Date: 26 November 2021

The Examining Authority's Schedule of changes to the Applicant's draft Development Consent Order

Application by National Highways for an Order Granting Development Consent for the A47 Blofield to North Burlingham scheme

DRAWING TITLE
WORKS PLANS REGULATION 5(2)(j) SHEET 6 OF 8

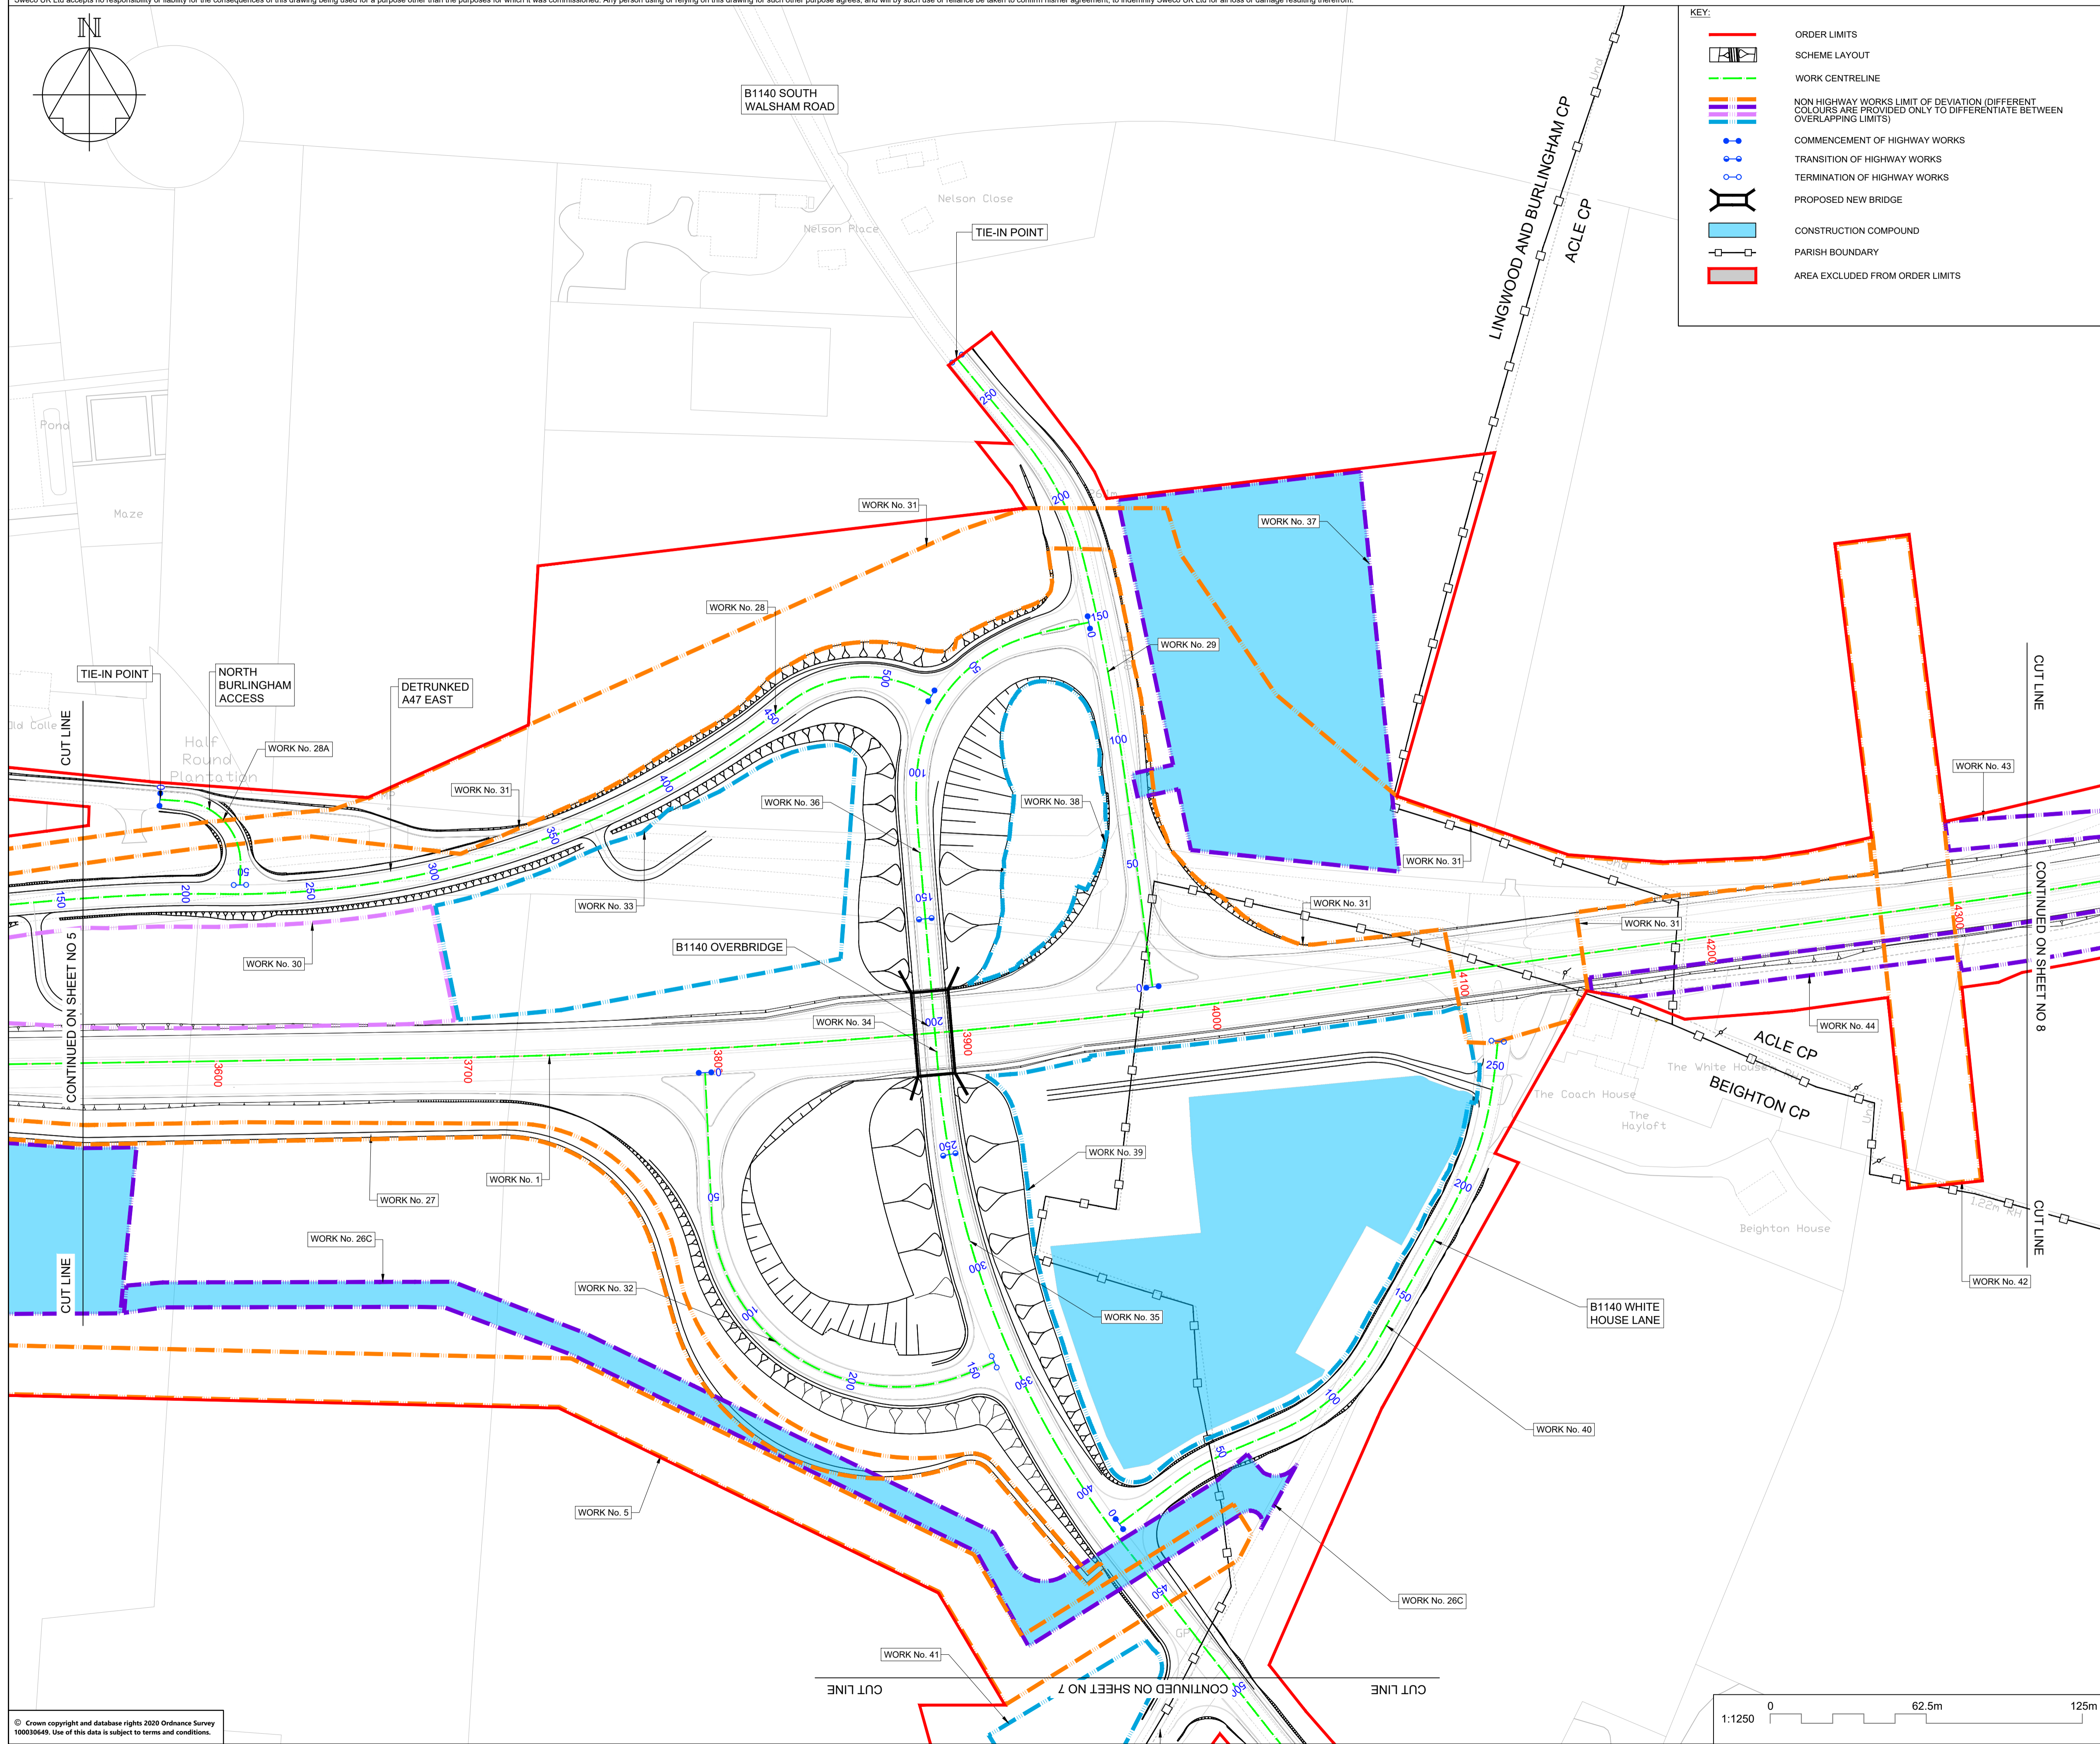
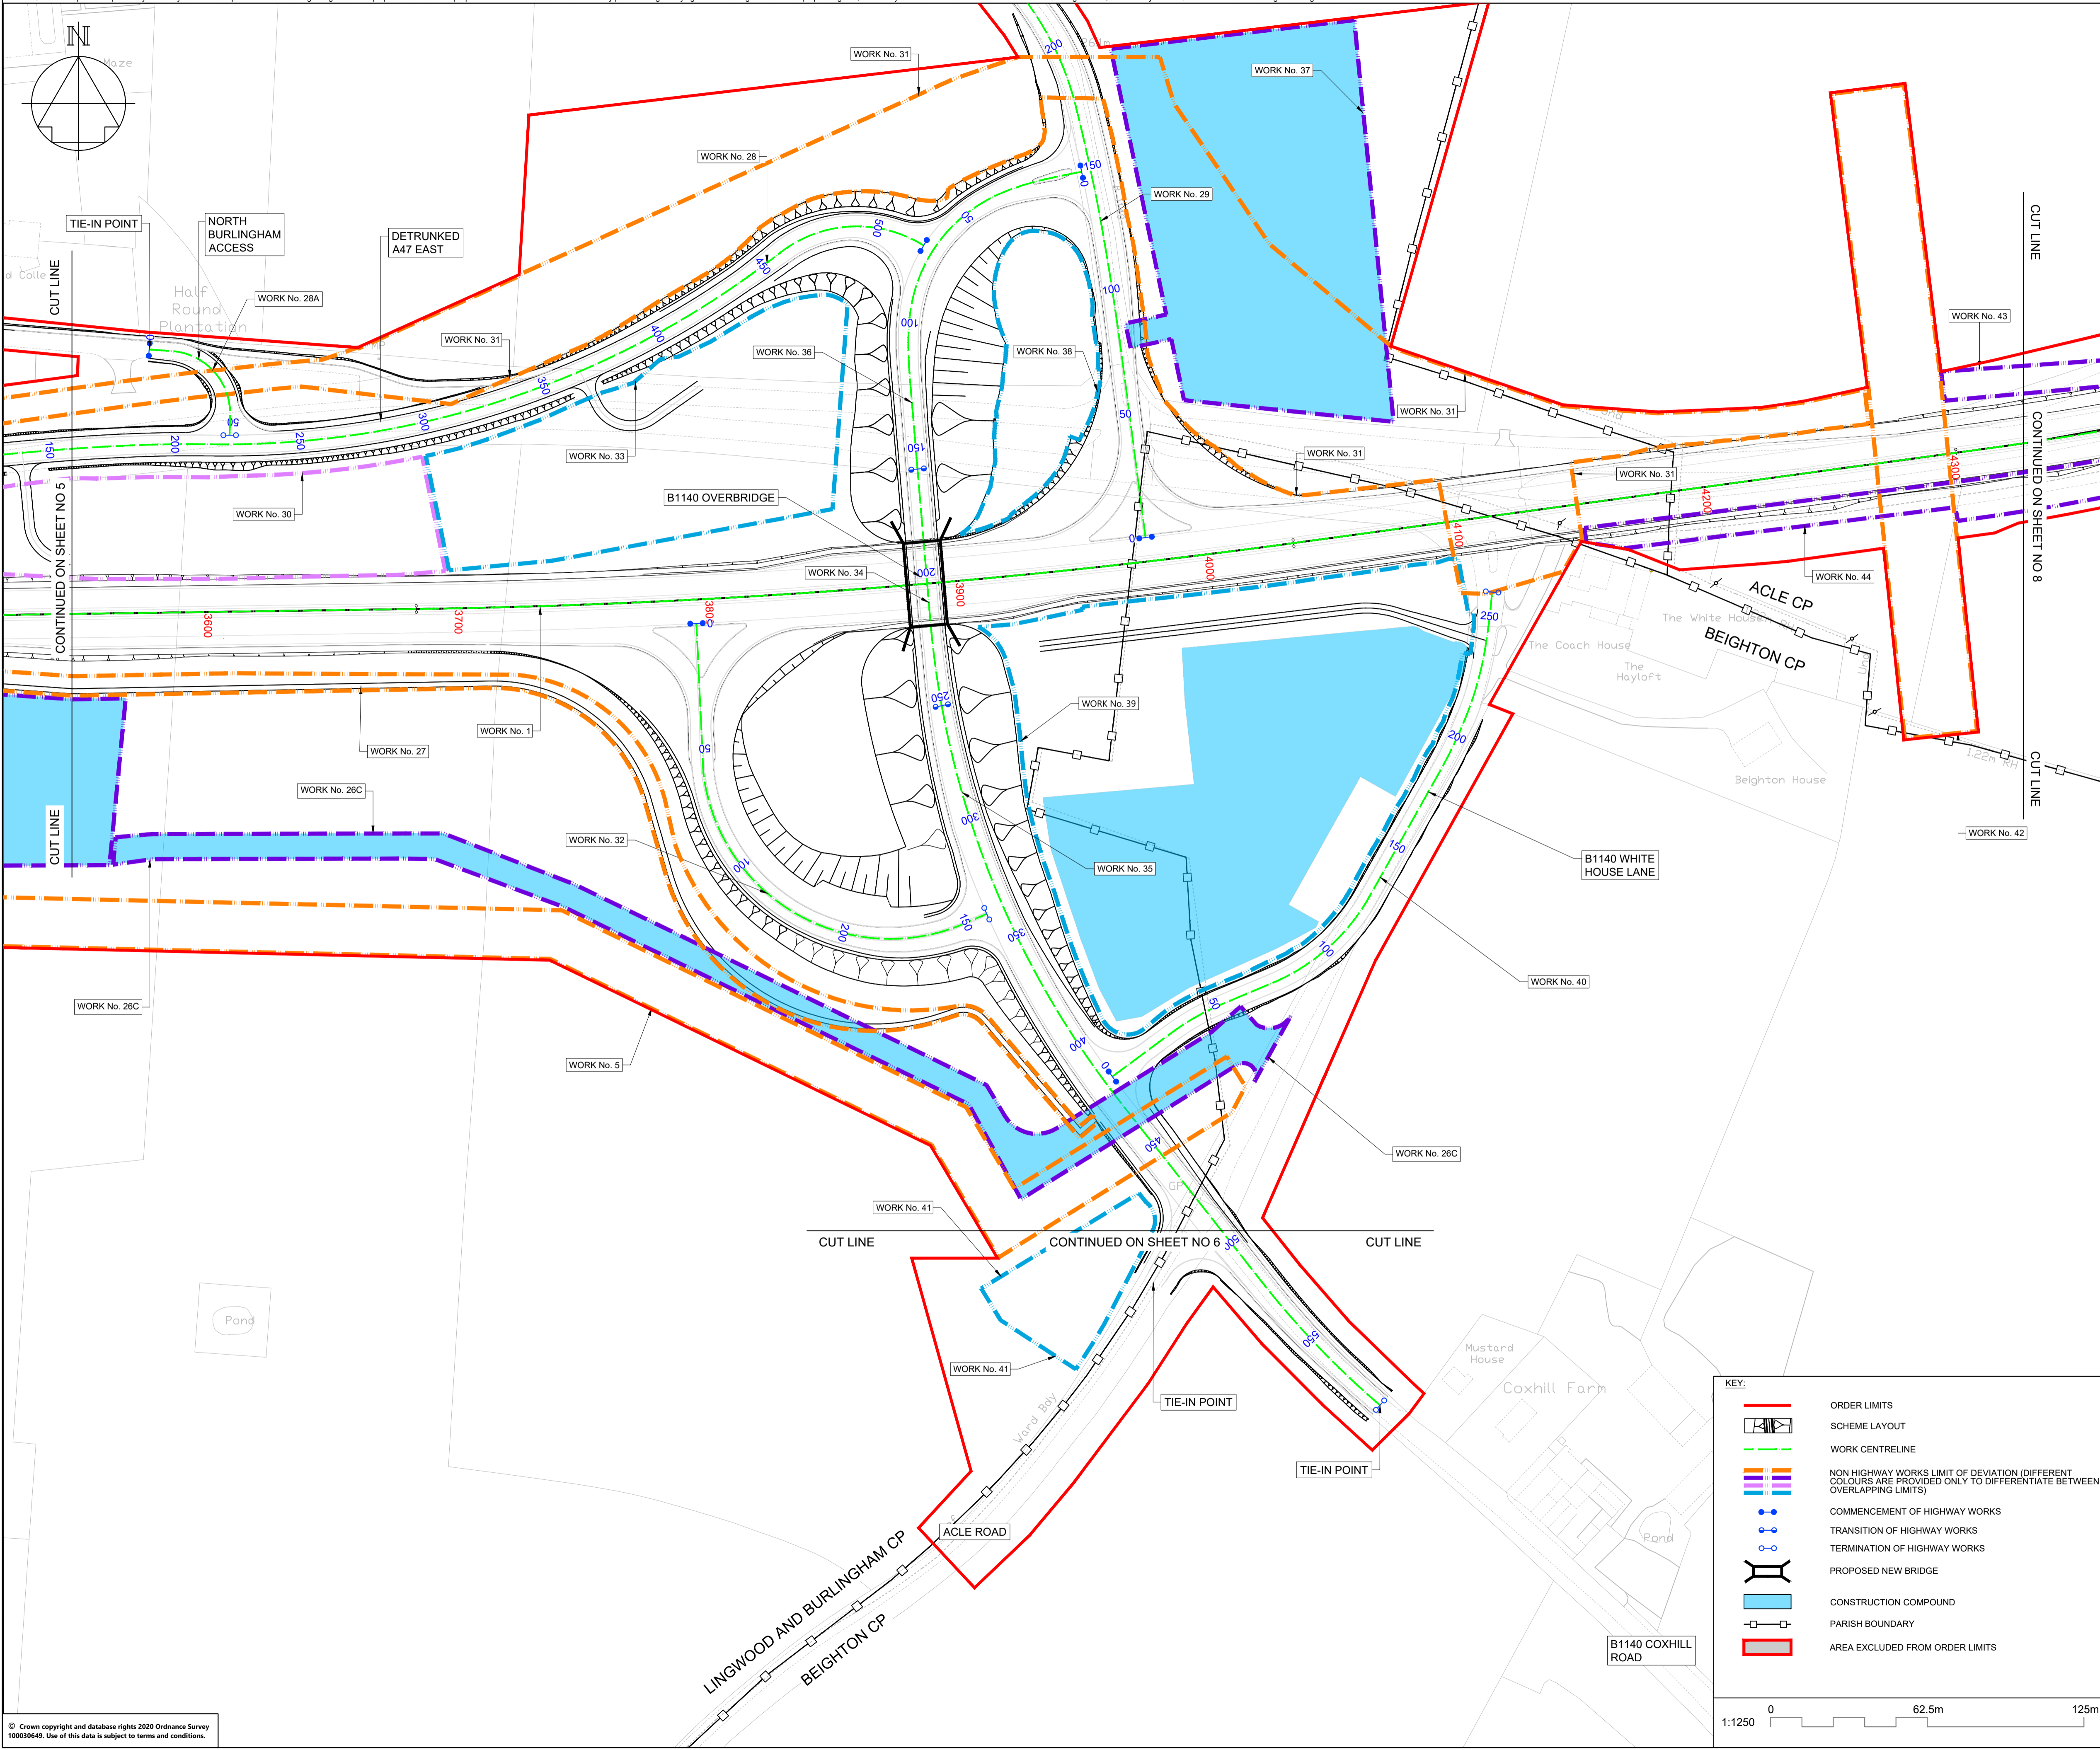
Schedule 1	Work No. 37 – temporary compound east of South Walsham Road and north of Work No. 1, shown on sheet numbers 6 and 7 of the works plans;	For consistency with how other work numbers are written.
Requirement 11	Any permanent and temporary fencing and other means of enclosure for the authorised development must be constructed and installed in accordance with Manual of Contract Documents for Highway Works maintained by or on behalf for of the undertaker except where any departures from that manual are agreed in writing by the Secretary of State in connection with the authorised development.	This appears to be a typographical error
